From: Thomas Callaway
Sent: 28 October 2015 14:51
To: Planning.Responses
Subject: RE: Planning Consultation on: Y/77/15/PL

Engineers comments in respect to surface water drainage:

**Planning Permission
APPLICATION NO:** Y/77/15/PL

Description of Works: Change of use to convert existing barn to a residential dwelling. Single storey extension to east & north facing elevations. Patio & car parking

Site Plan

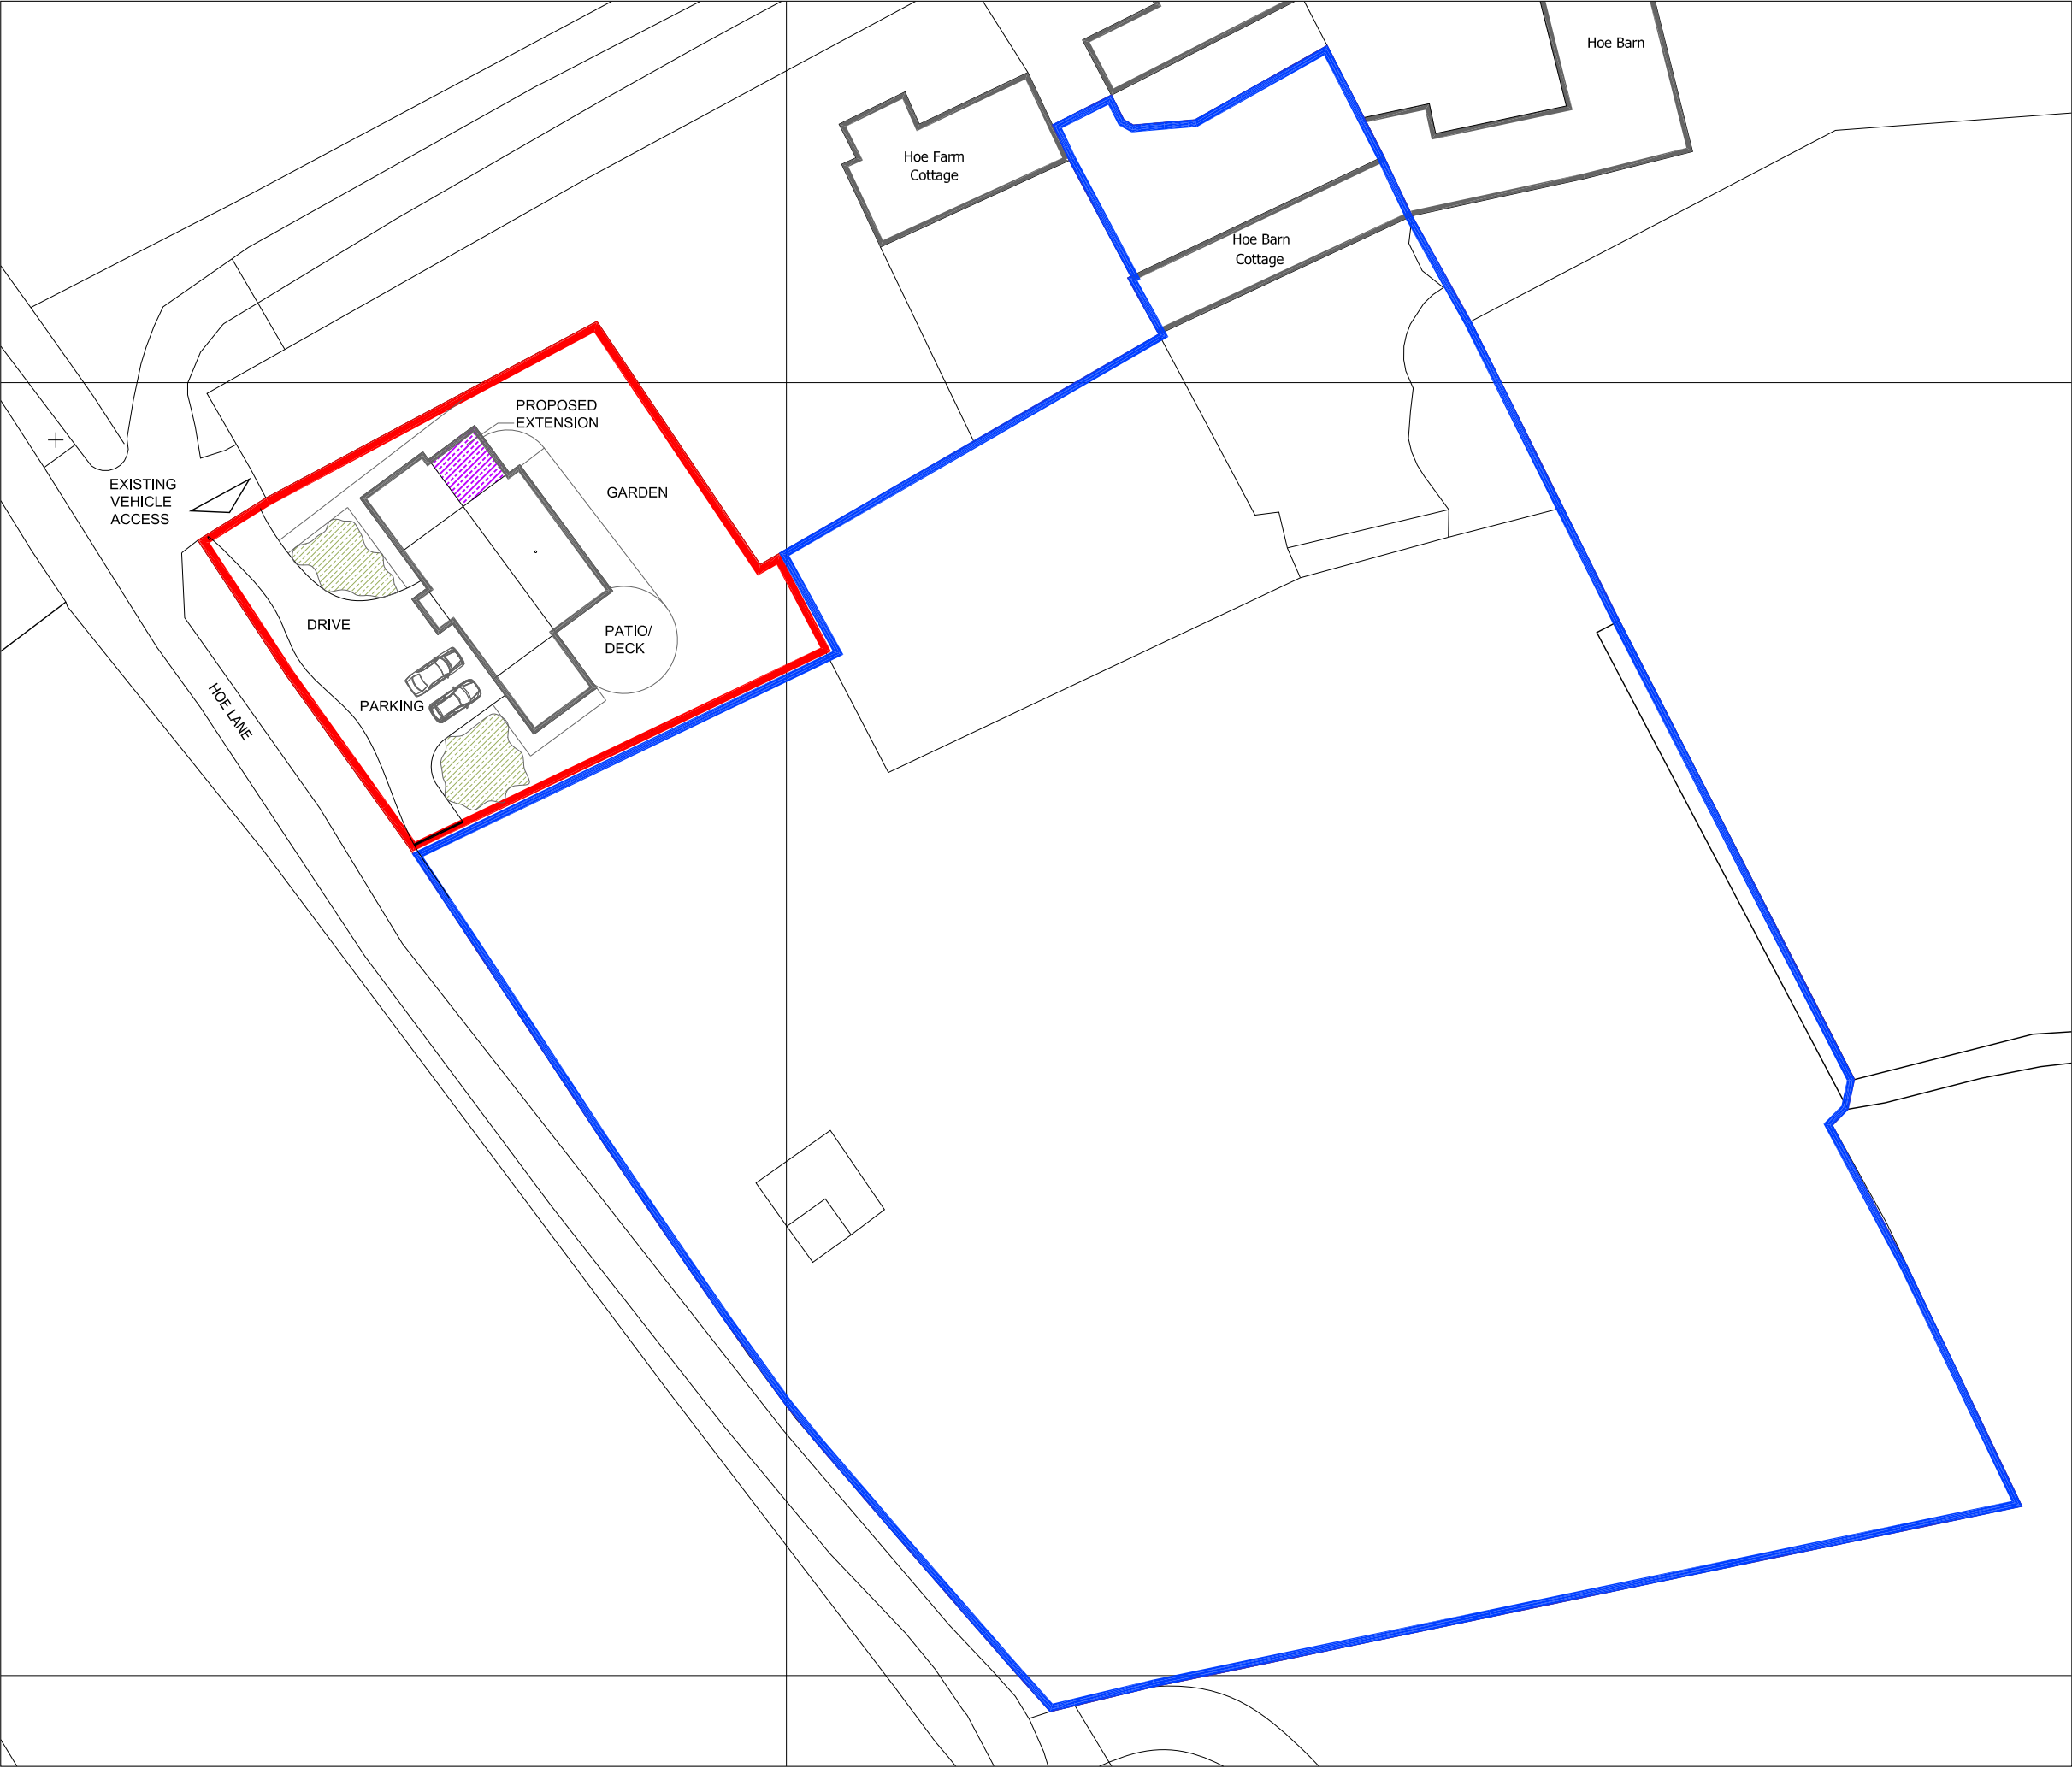
The applicant states that surface water will be discharged to soakaways

Infiltration rates for soakage structures are to be based on percolation tests undertaken in the winter period and at the location and depth of the proposed structures. The percolation tests must be carried out in accordance with BRE 365, CIRIA R156 or a similar approved method and cater for the 1 in 10 year storm between the invert of the entry pipe to the soakaway, and the base of the structure. It must also have provision to ensure that there is capacity in the system to contain below ground level the 1 in 100 year event plus 30% on stored volumes, as an allowance for climate change. Adequate freeboard must be provided between the base of the soakaway structure and the highest recorded annual groundwater level identified in that location.

Any SuDS or soakaway design must include adequate groundwater monitoring data to determine the highest winter groundwater table in support of the design. The applicant is advised to discuss the extent of groundwater monitoring with the Council's Engineers. Supplementary guidance notes are also enclosed for information.

A rising main sewer is located close to the property. Southern Water should be consulted to confirm its location and what easement is required, as this will affect where any soakaway can be located.

Please apply standard conditions ENGD2A.
